Your ref: BE/15/11
Our Ref: AR15.11/D

Shripney Garden Caravan Park, Shripney Lane, Bognor Regis

We refer to your email of 6th January 2012 requesting amendments to the application for the extension to existing caravan park to provide 12 no. additional mobile homes, associated parking area, formation of access and construction of electrical intake housing (amendment to application BE/42/10).

SHRIPNEY GARDEN CARAVAN PARK, SHRIPNEY LANE, SHRIPNEY
Proposals 01 B
Nov 2011

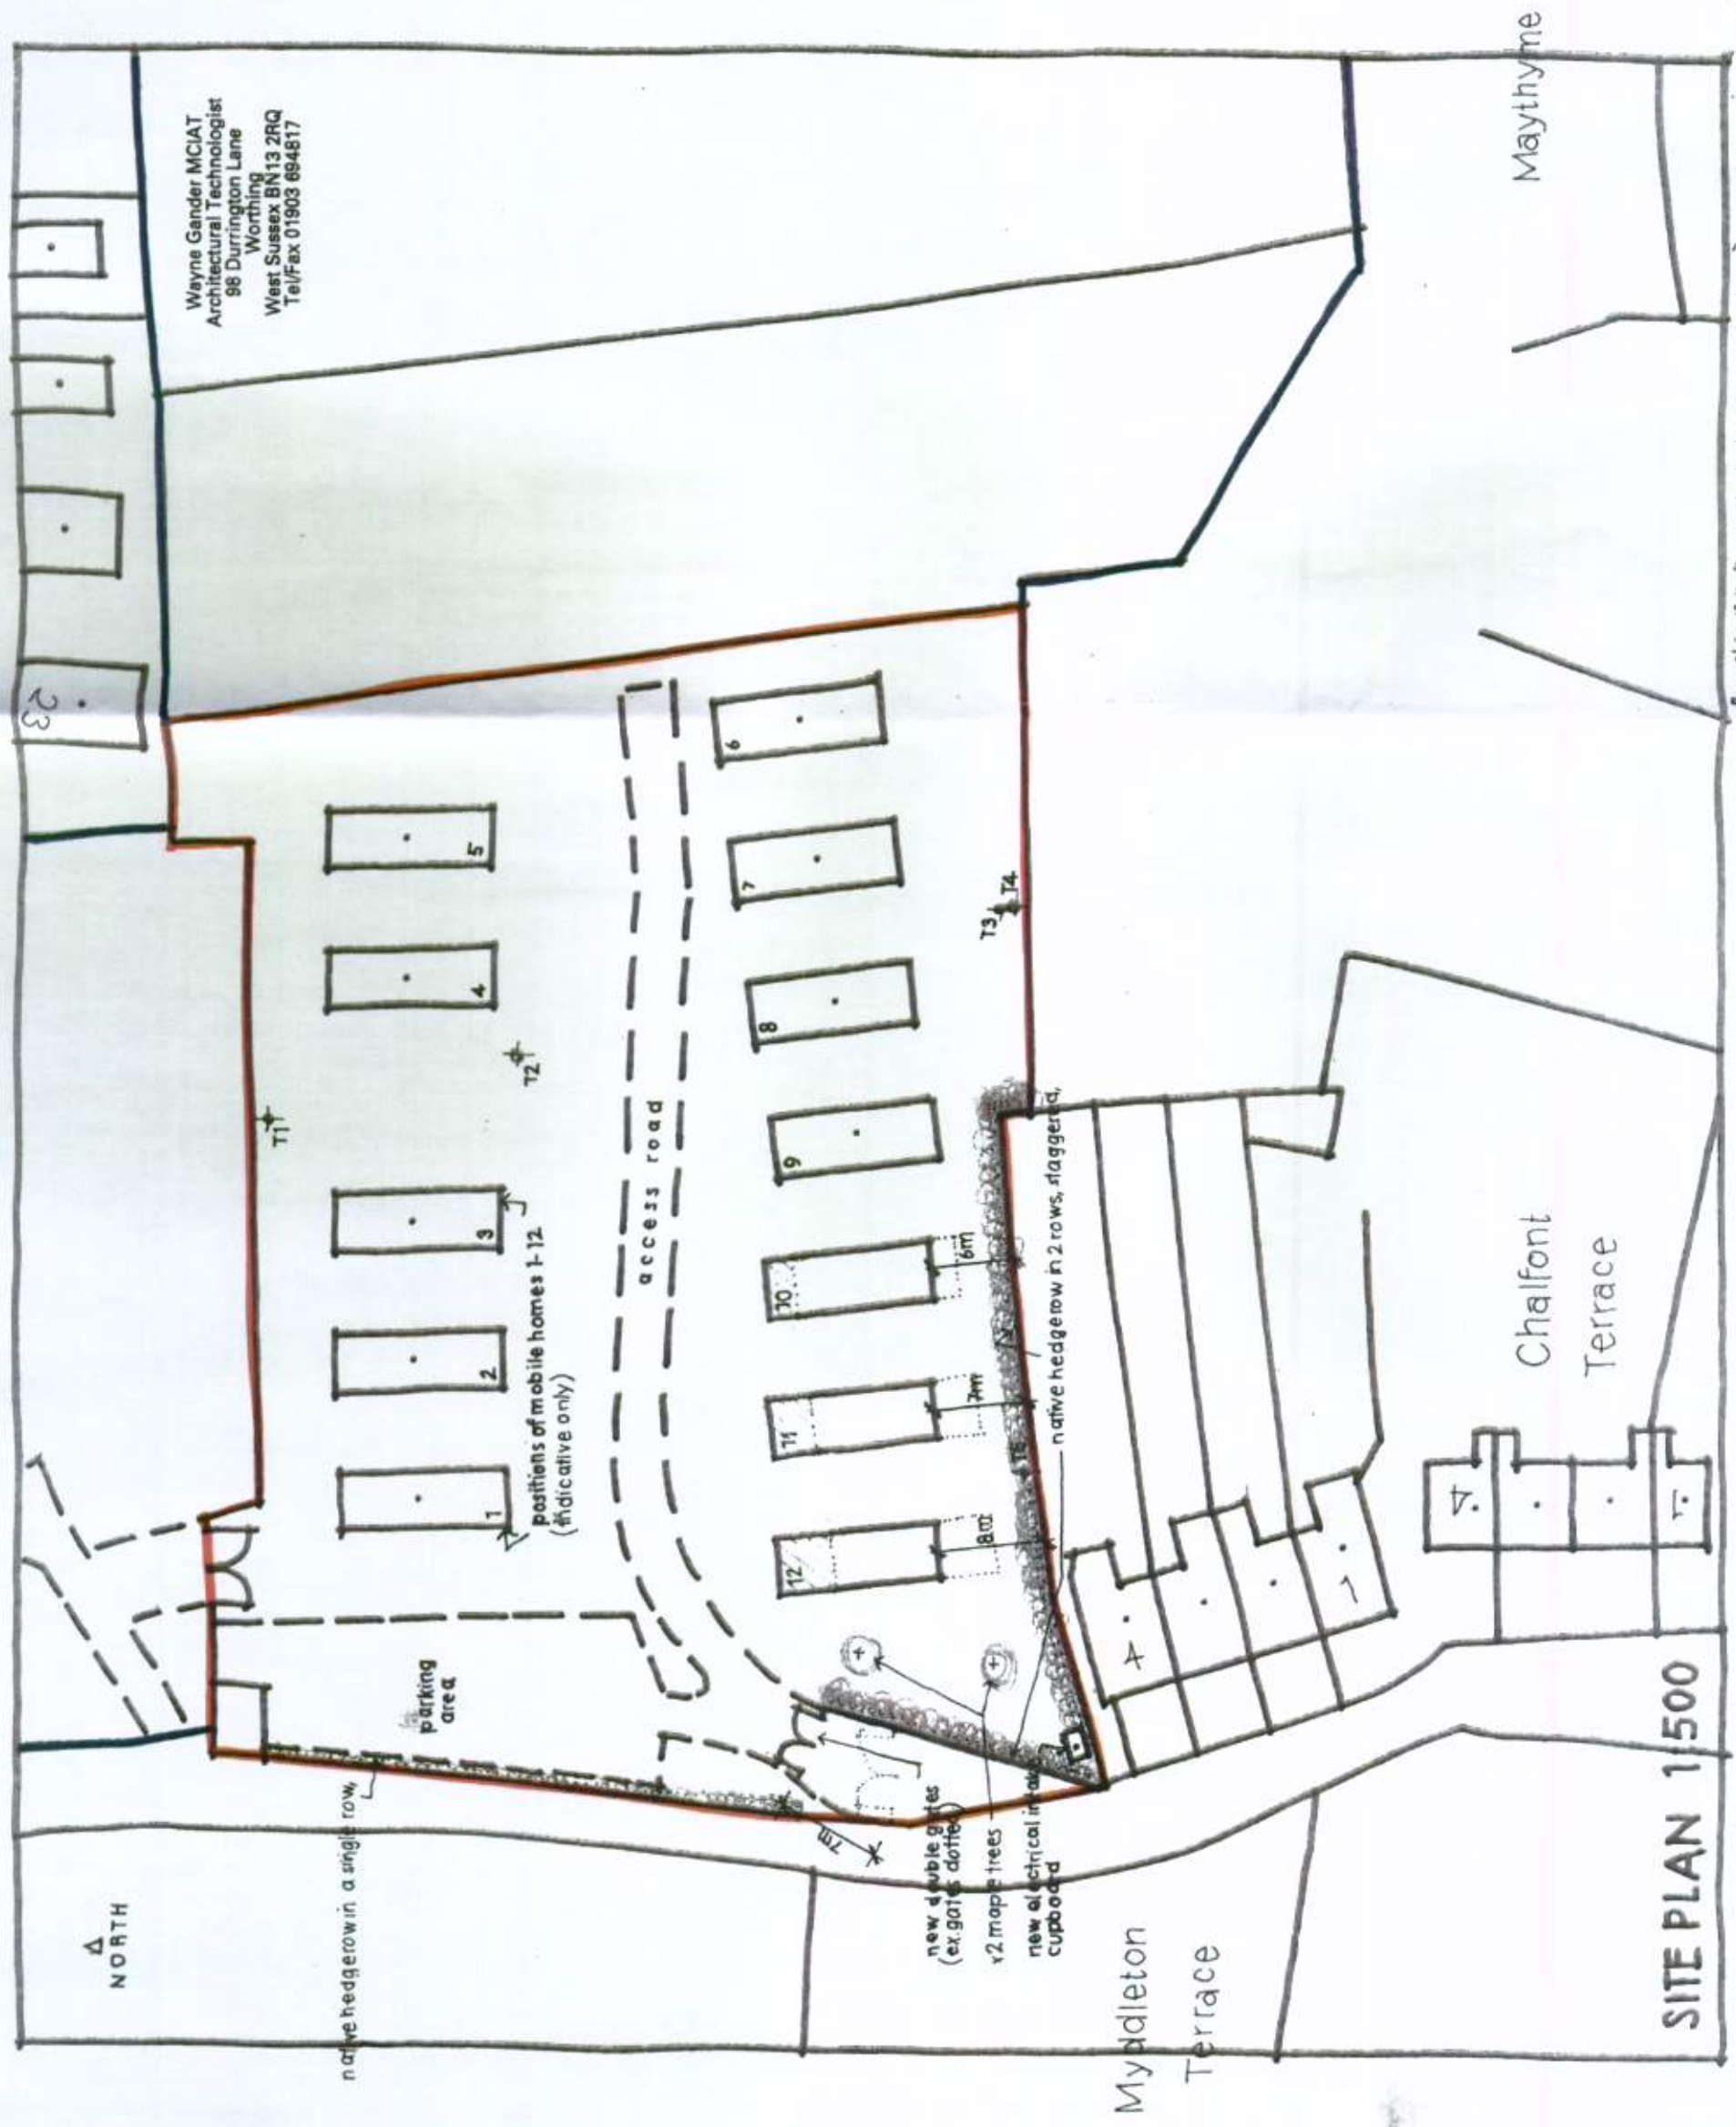
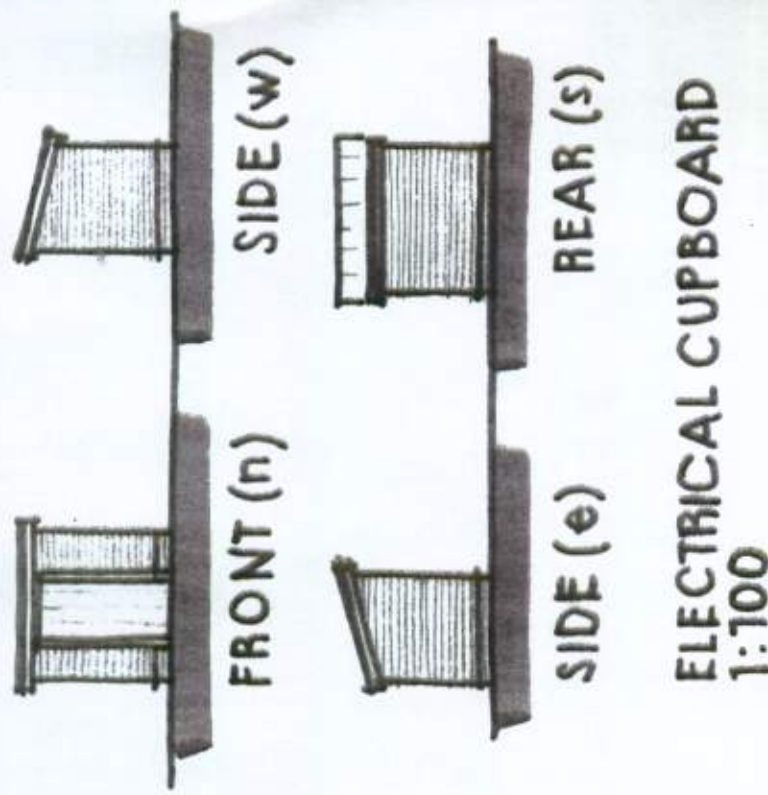
Firstly, you have requested a detailed landscaping scheme along the roadside and the boundary with Myddleton Terrace. We therefore enclose an amended site plan on which a native hedgerow is shown to be planted along these boundaries. The southern boundary from the electrical intake box to the rear boundary of Myddleton Terrace and the boundary along the access from the electrical intake box to the access gates will be planted with a double staggered row. The road frontage adjacent to the parking area and extending southwards to the access point will be planted with a single row due to space limitation. It is intended that the hedgerow will comprise:

- Crataegus monogyna (Hawthorn) 50%
- Prunus spinosa (Blackthorn) 20%
- Cornus sanguinea (Dogwood) 10%
- Ligustrum vulgare (Wild Privet) 10%
- Rhamnus frangula (Alder Buckthorn) 5%
- Ilex aquifolium (Holly) 5%

The species will be planted in 2 staggered rows 300mm apart and each plant 500mm apart within the row.

Notwithstanding the above comments, our client clearly wants to resolve this matter and complete the development and therefore is willing to adjust the position of the first three bases (nos 10, 11 and 12). It is therefore proposed that each base is reduced on its southern side and extended on its northern side towards the access road. The re-

separation distance from the southern boundary will be as annotated on the plan and accords with the distances on the indicative approved plan. This, taken together with the proposed planting, will result in a layout comparable in terms of impact with the approved indicative plan.
